Harnett County
Application Tracking Individual Step Maintenance

Application number : 16 50038611
Application type : CP ADD & ALTER RESIDENTIAL
Revision number :
Path/Step/Seq/Agency : A 20 00 ENVIRONMENTAL HEALTH
Date submitted, resulted . . . 72716 _____
Status code (F4) : _____
Reviewed by (F4) : _____
Revised est cpl date 82216
Copies of plans : _____

305 Ruth Circle, Fuquay Varina  
 Back yard to show location of new deck platform

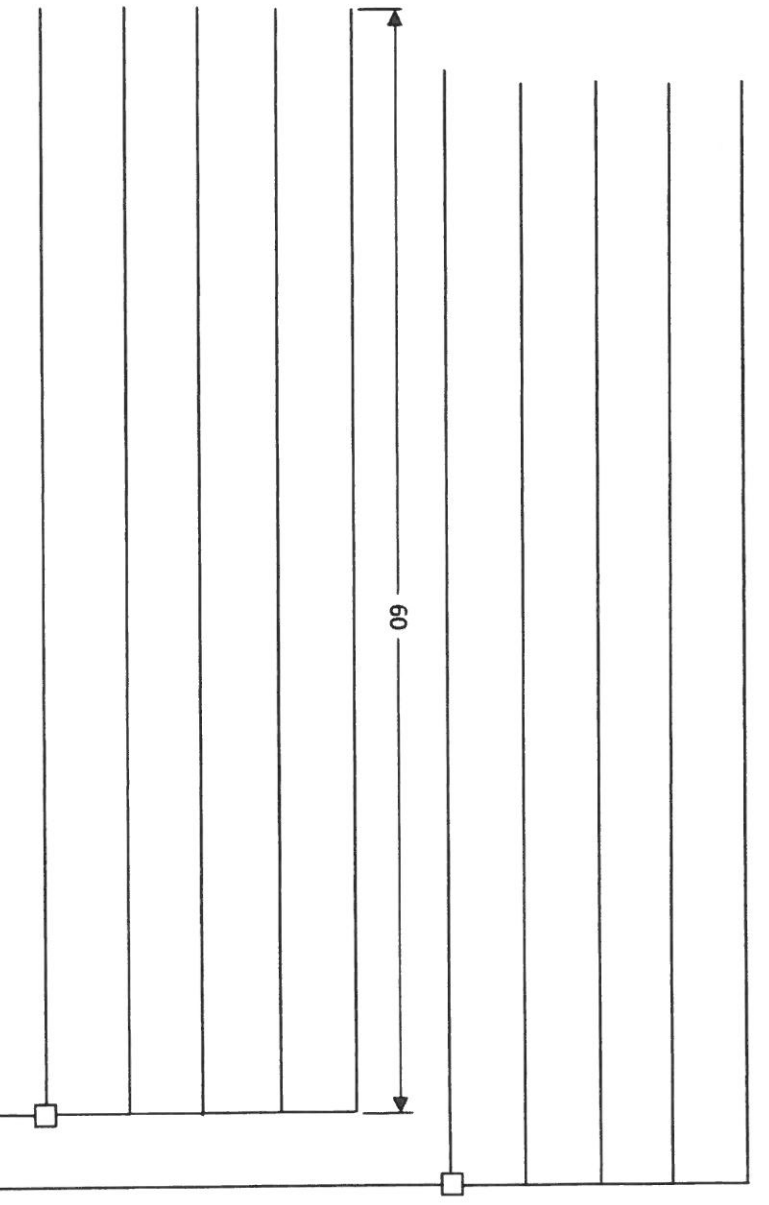
- 1.000 PER GRAHAM BYRD, DECK WILL BE BUILT OVER SYSTEM. GAVE
HOMEOWNER OPTIONS VERBALLY BUT THEY DO NOT WISH TO PURSUE
AT THIS TIME.
